Your Reference	SSD8873789
Our Reference	NCA/5/2020
Contact	Kate Lafferty
Telephone	9806 5393
Email	klafferty@cityofparramatta.nsw.gov.au

22 June 2021

**COUNCIL COMMENTS – RESPONSE TO EXHIBITION
86 Chelmsford Avenue, Epping (New Epping South Primary School)**

PROJECT: EPPS - SSDA - 001
SERIES NUMBER: A

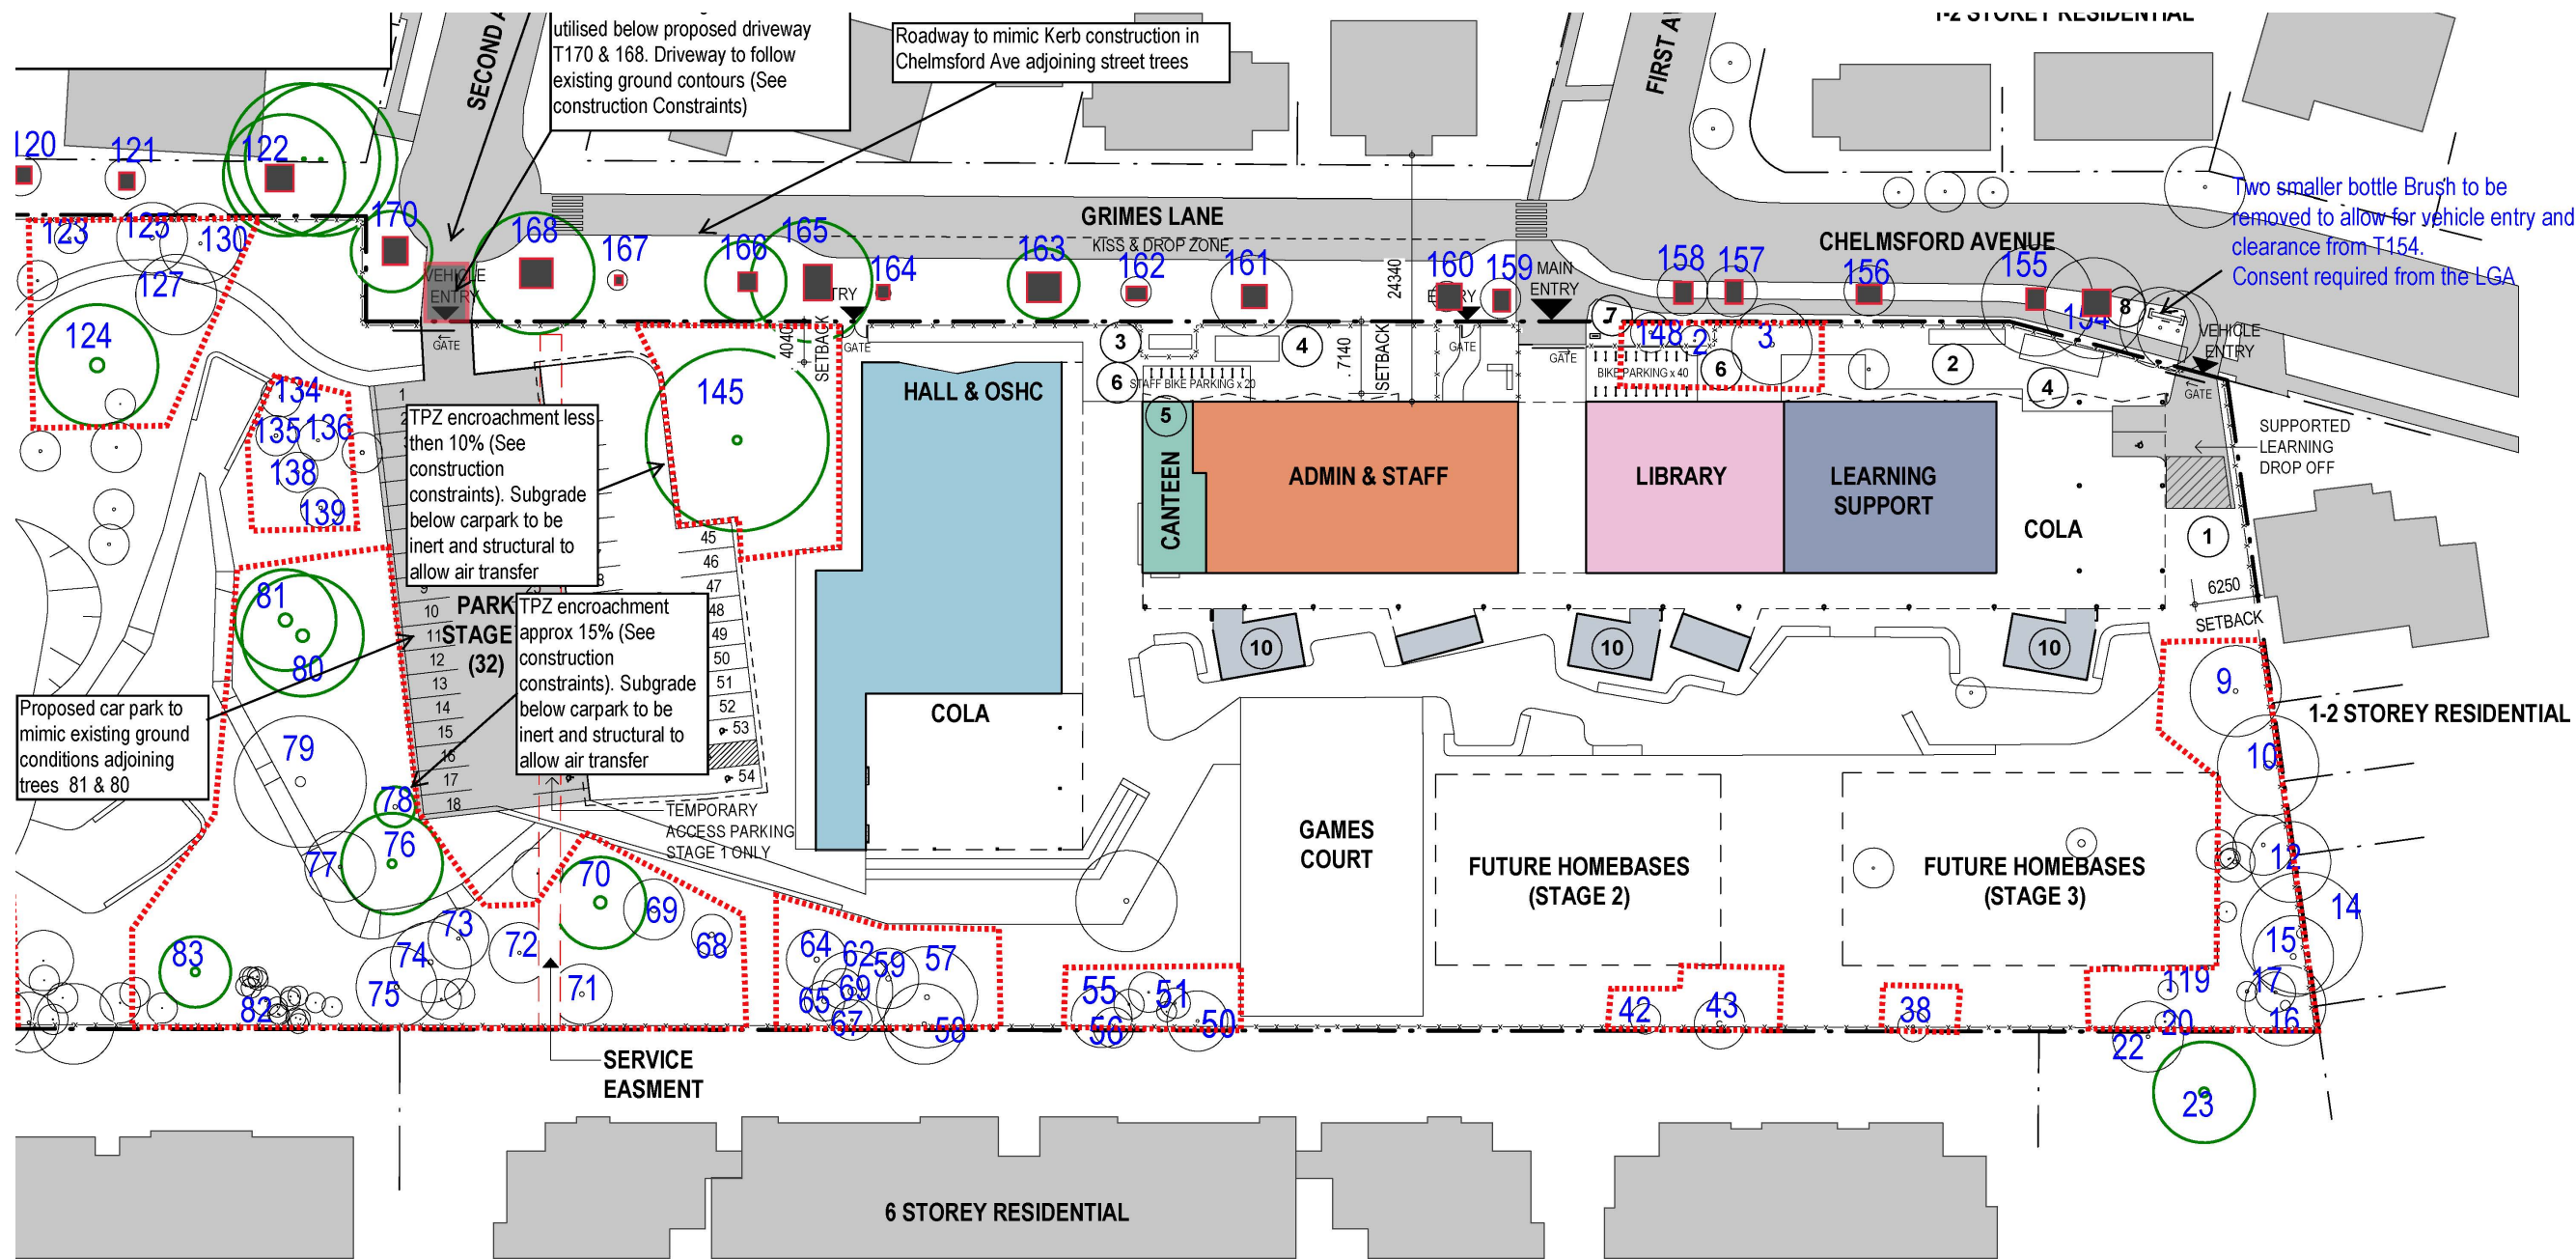
The plans do not provide sufficient detail to confirm that the design of the proposed at-grade car park complies with the Australian Standards. Space 18 and 54 are of particular concern, as it appears that an additional 300mm clearance may not have been provided to the fence and the blind aisle extensions have not been provided. Furthermore, the car park does not include any provisions to turn around and may result in long reversing manoeuvres.

A detailed plan of the at-grade car park is to be provided to confirm that the design is satisfactory. The plans must show all details and dimensions such and is to ensure compliance with AS 2890.1, AS 2890.2 and AS 2890.6.
